V1_Grading & Erosion Control (GEC) Plan_COMMENTS.pdf Markup Summary

PCD File PPR2610

FOUNTAIN VALLEY SCHOOL ACADEMIC CENTER

GESC COVER SHEET

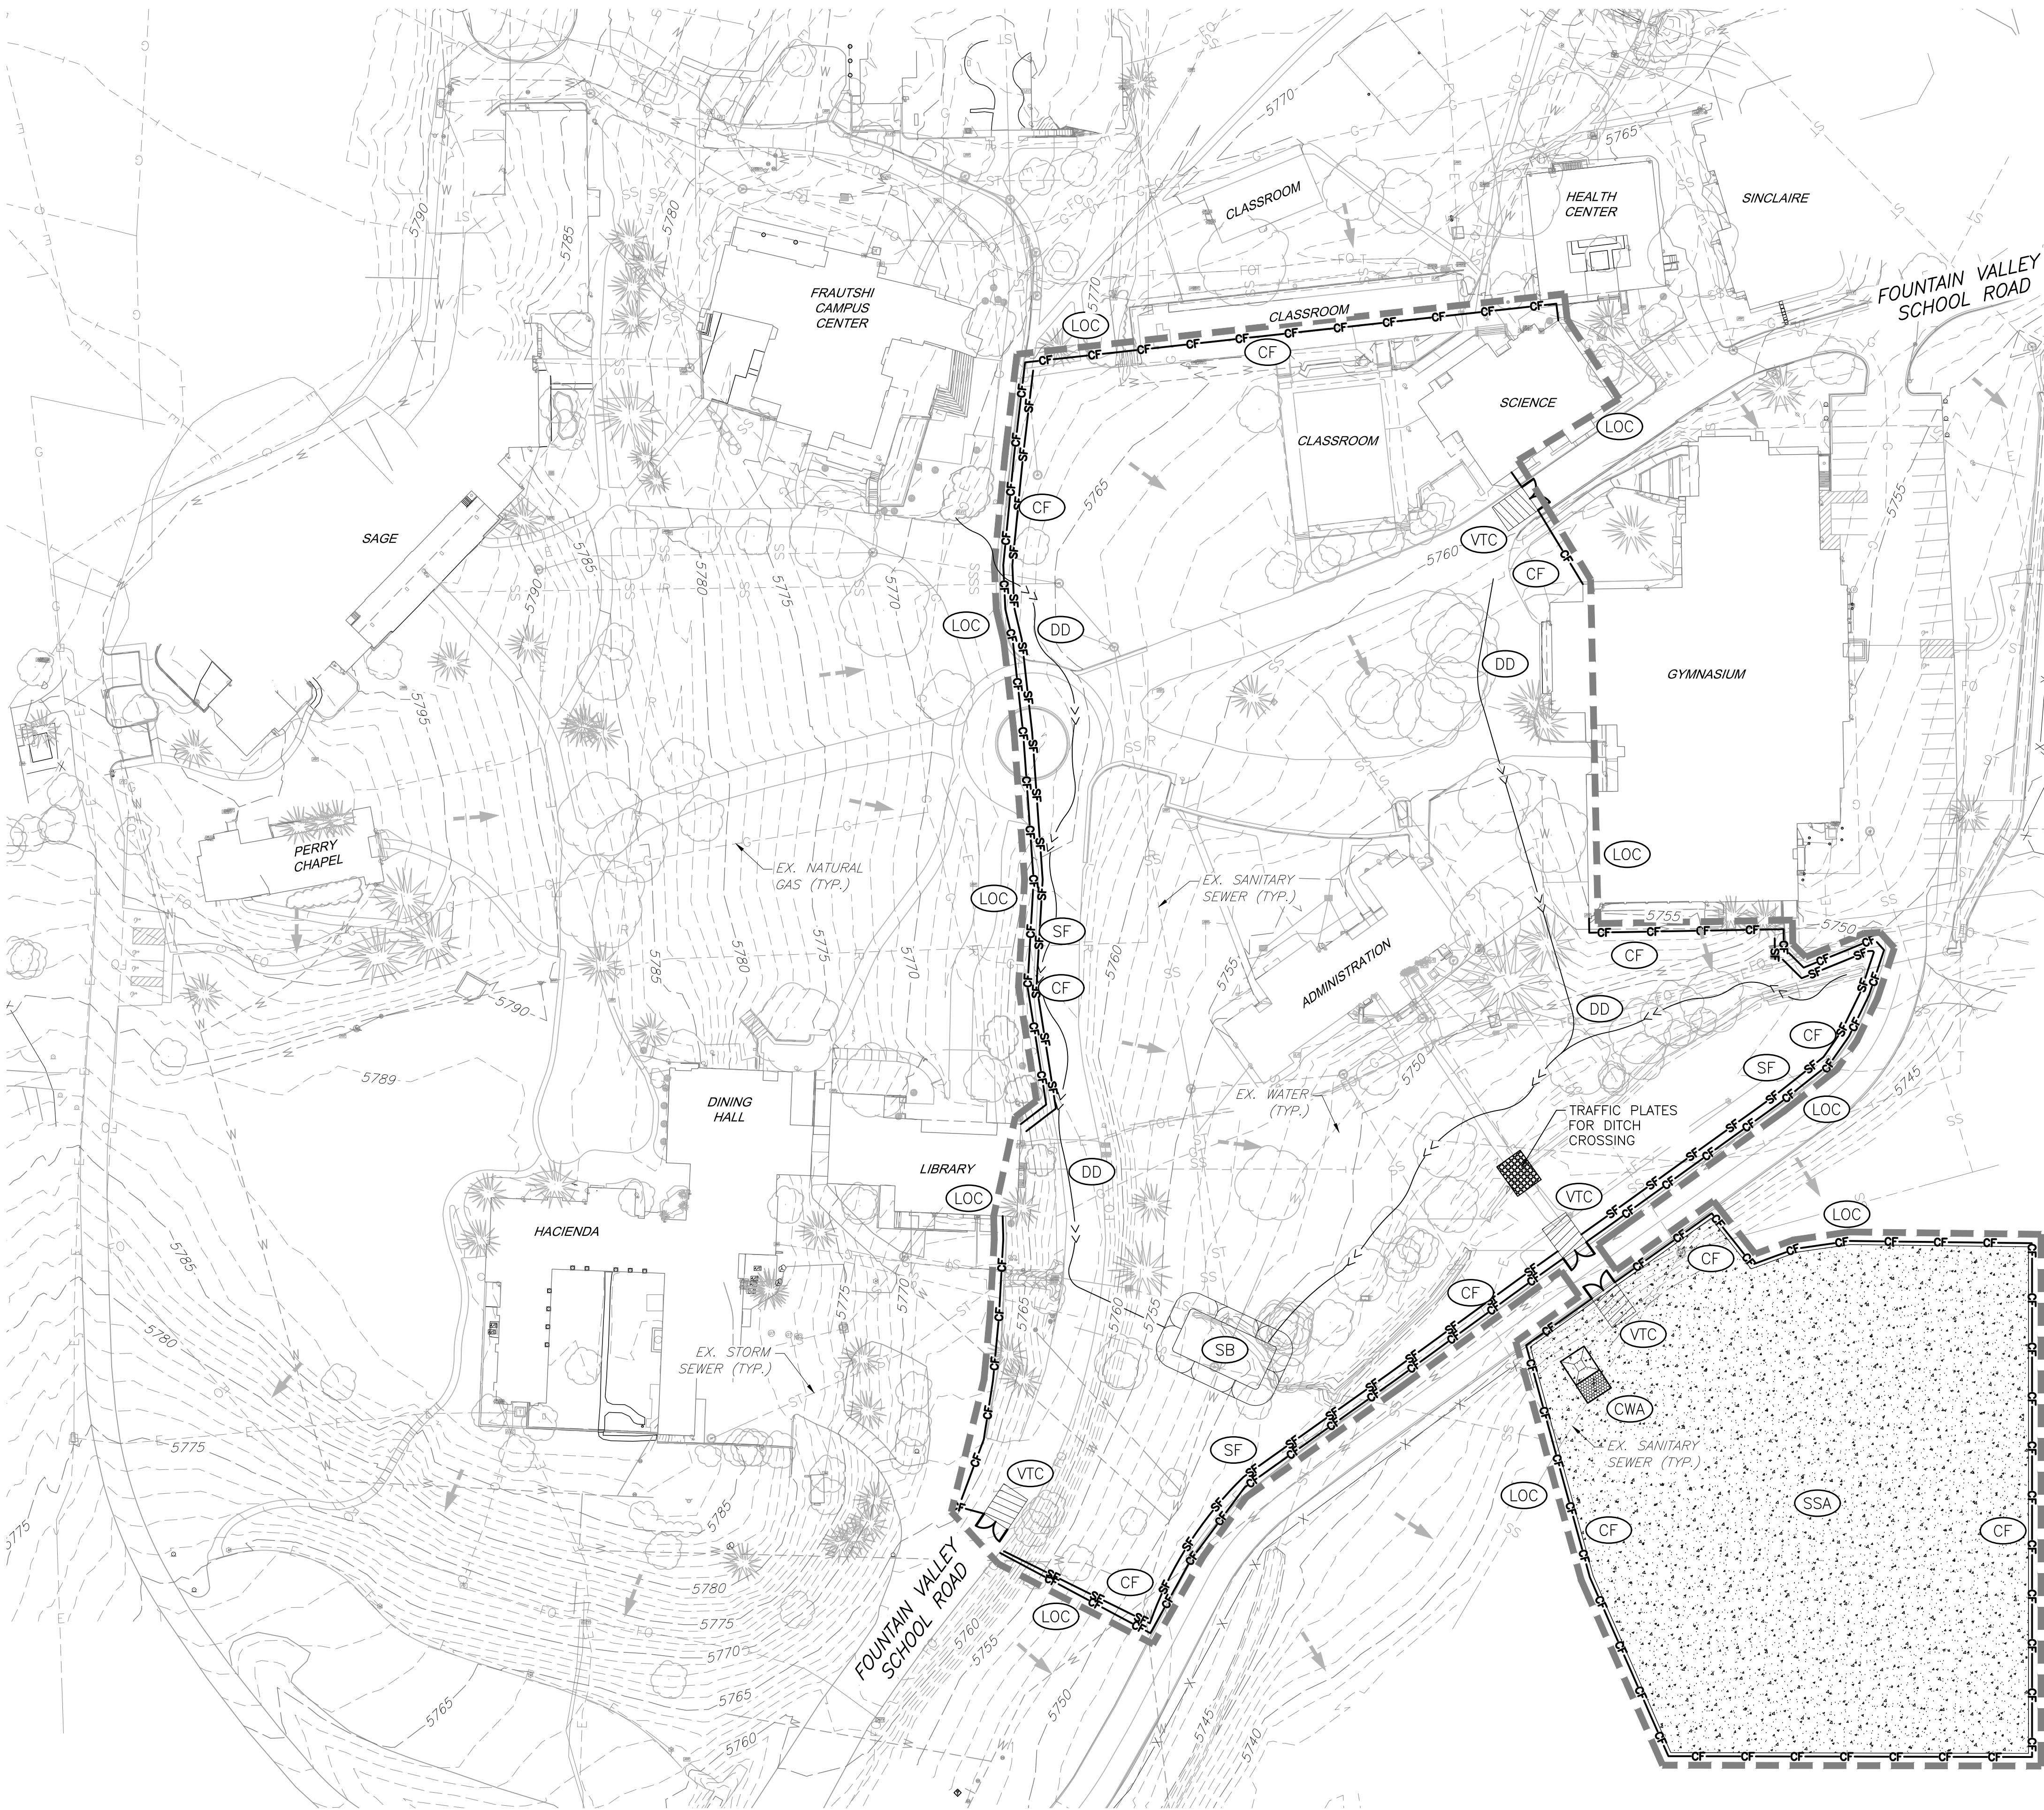
Use signature blocks for stand-alone GEC plan (no CDs)

Stamp and sign Engineer stamp all pages

MM Response:
Thank you for your comments, please see responses on GEC Plan Sheets.

SC-7

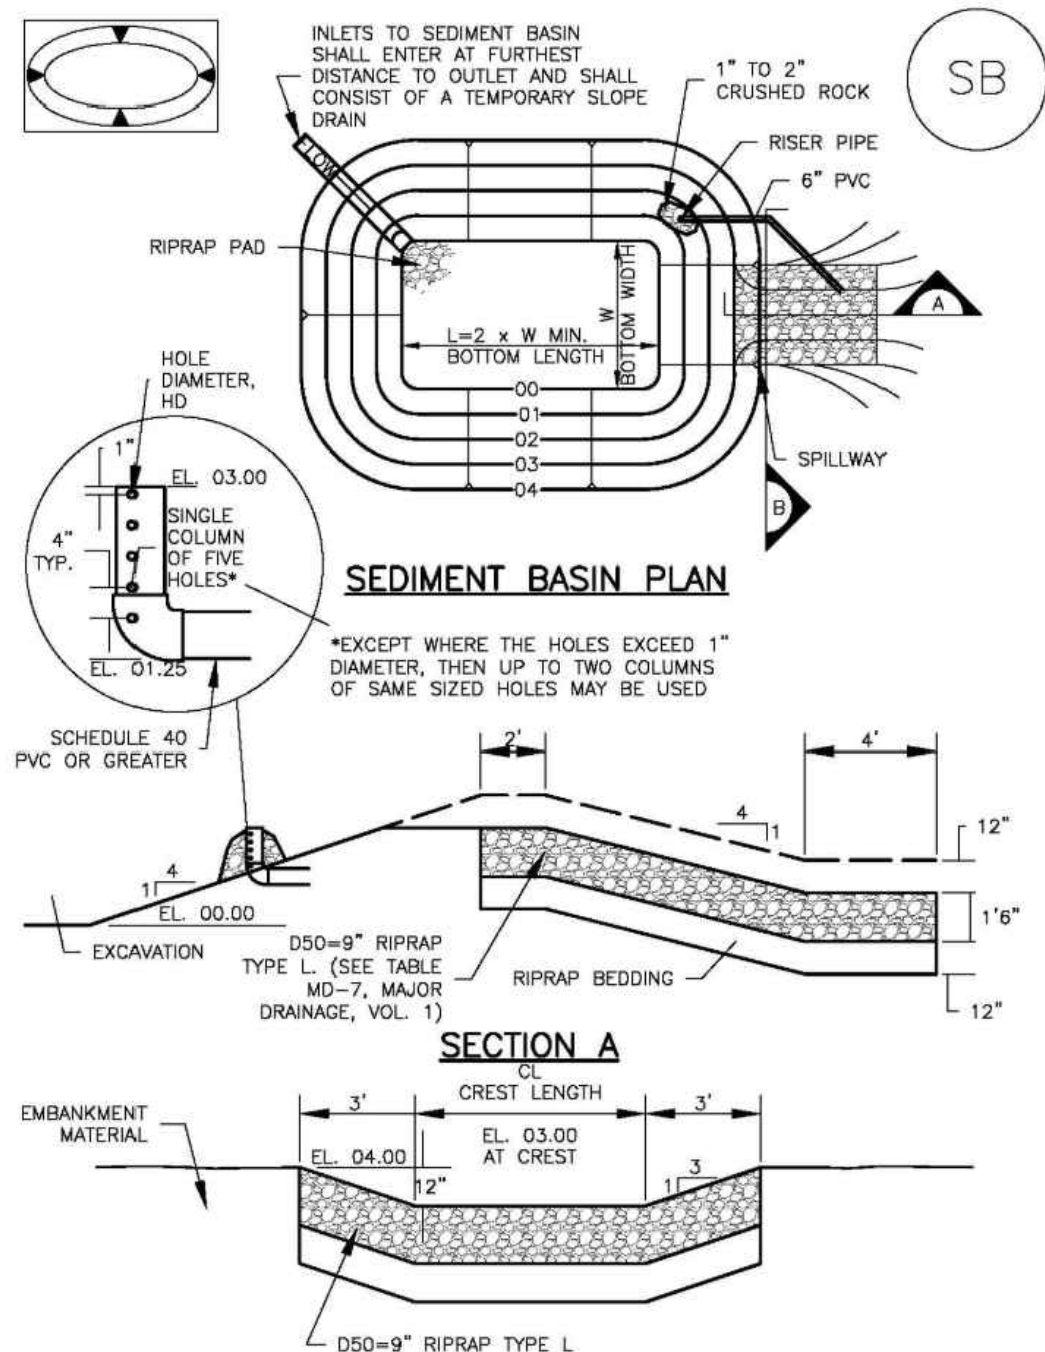
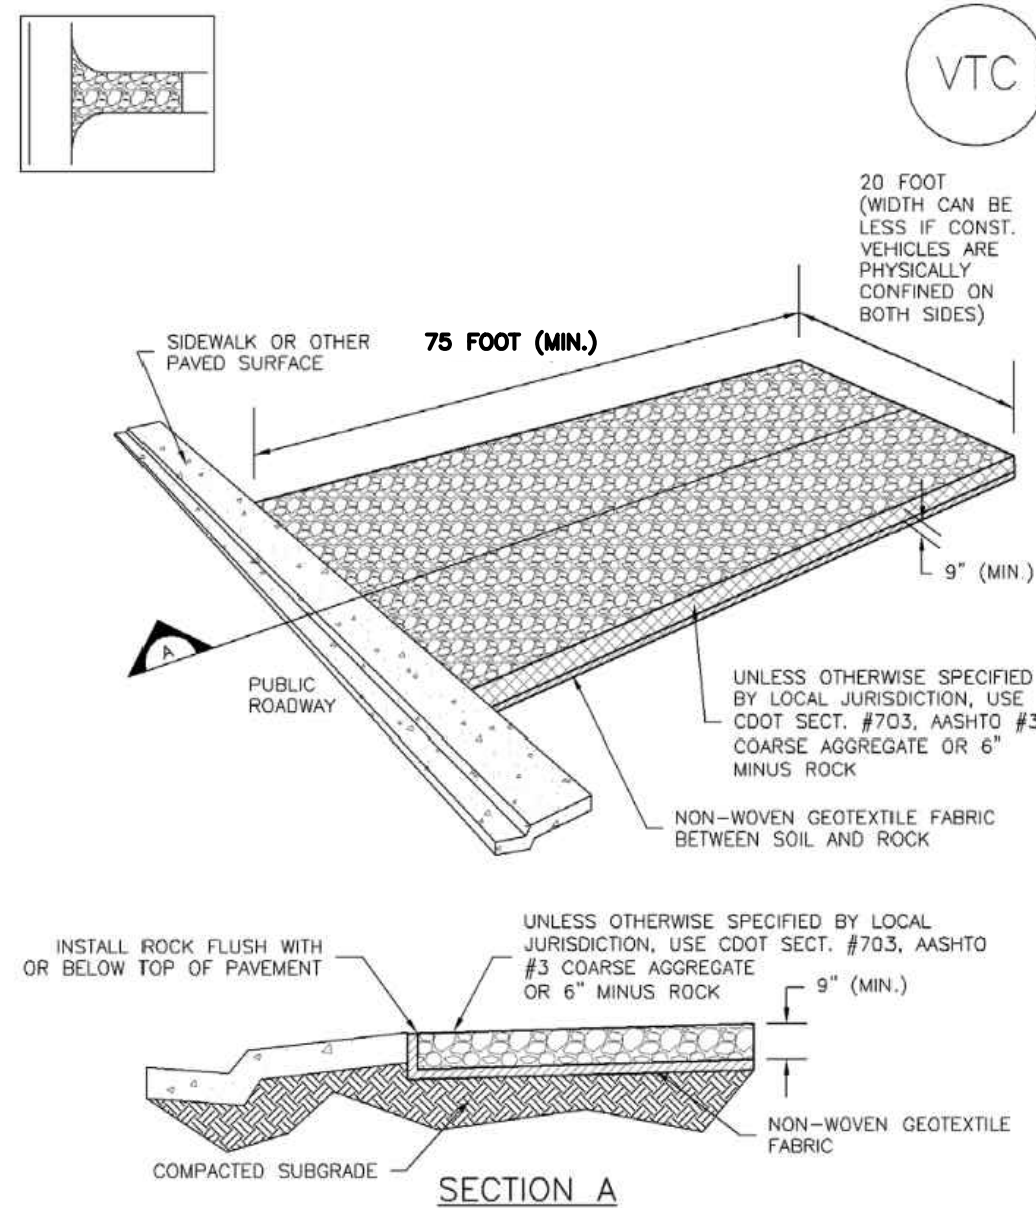
SC-7
 Please indicate which line in the table below should be used for the sediment basin, or provide other sizing details specific to the TSB for this site.

Please notate which line on the table below should be used for the sediment basin, or provide other sizing details specific to the TSB for this site

SM-4 Vehicle Tracking Control (VTC)

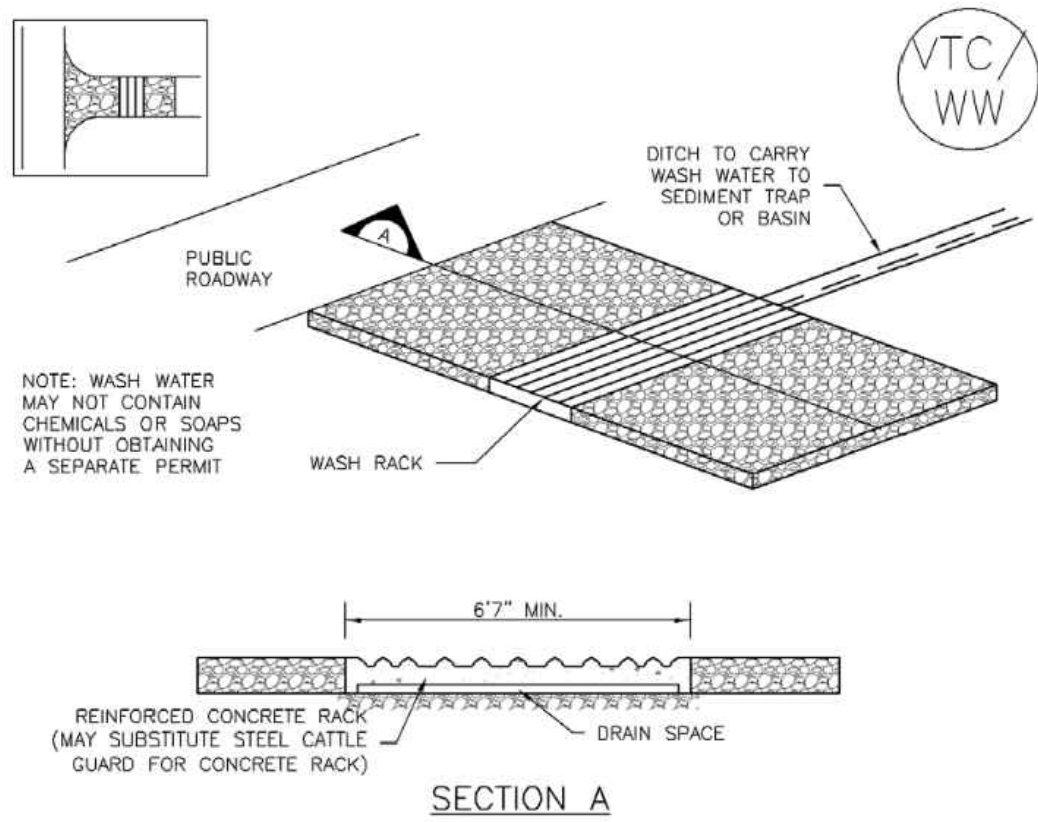
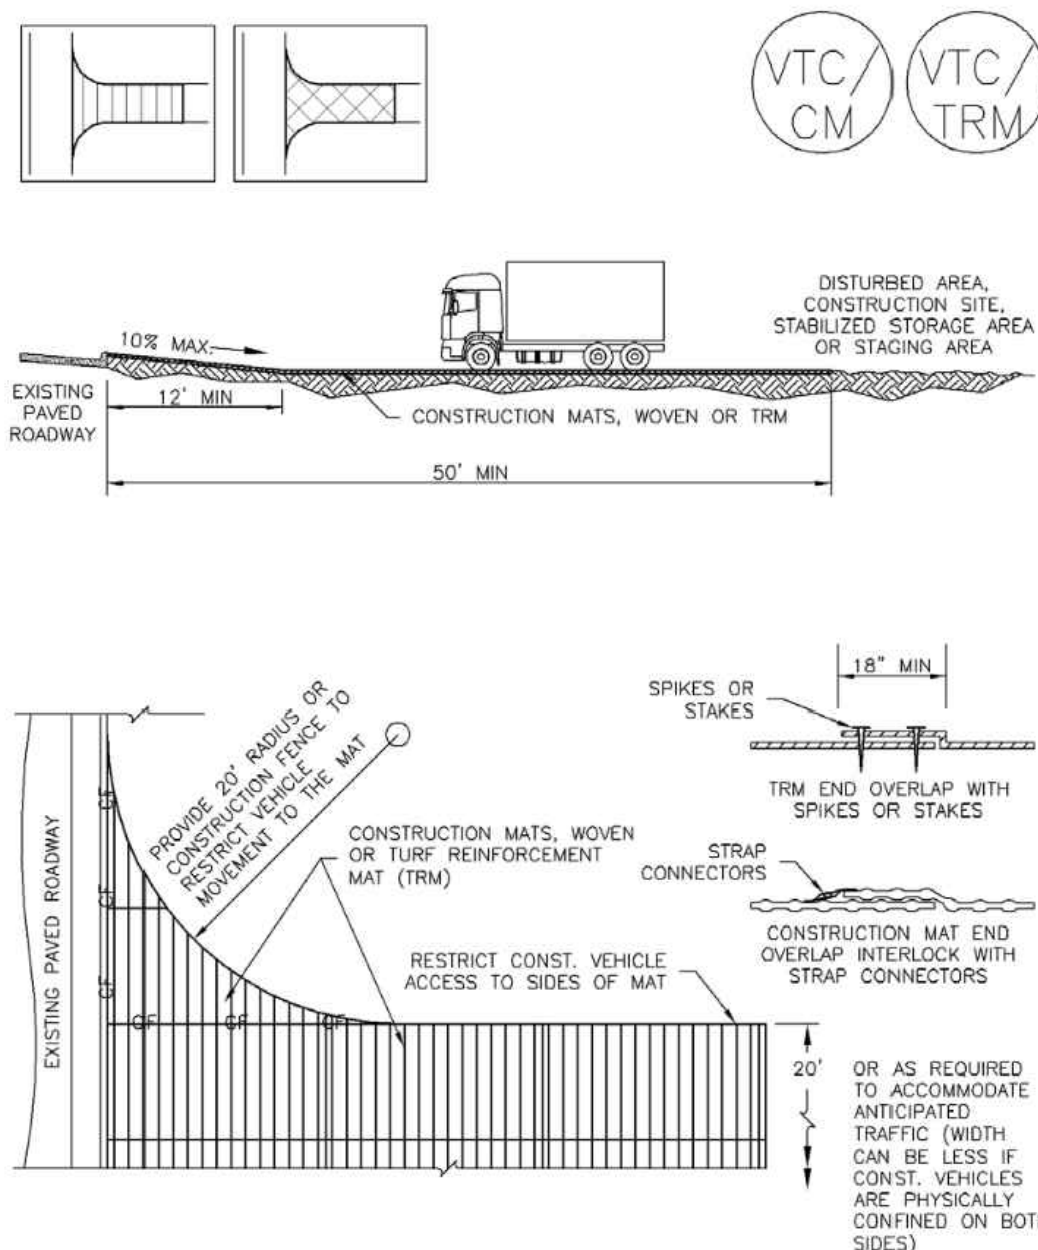
Replace with EPC approved VTC detail (VT-1 and VT-2 in DCMv2, Chap 3.3) or revise to be 75ft min length.

Replace with EPC approved VTC detail (VT-1 and VT-2 in DCMv2, Chap 3.3) or revise to be 75ft min length.
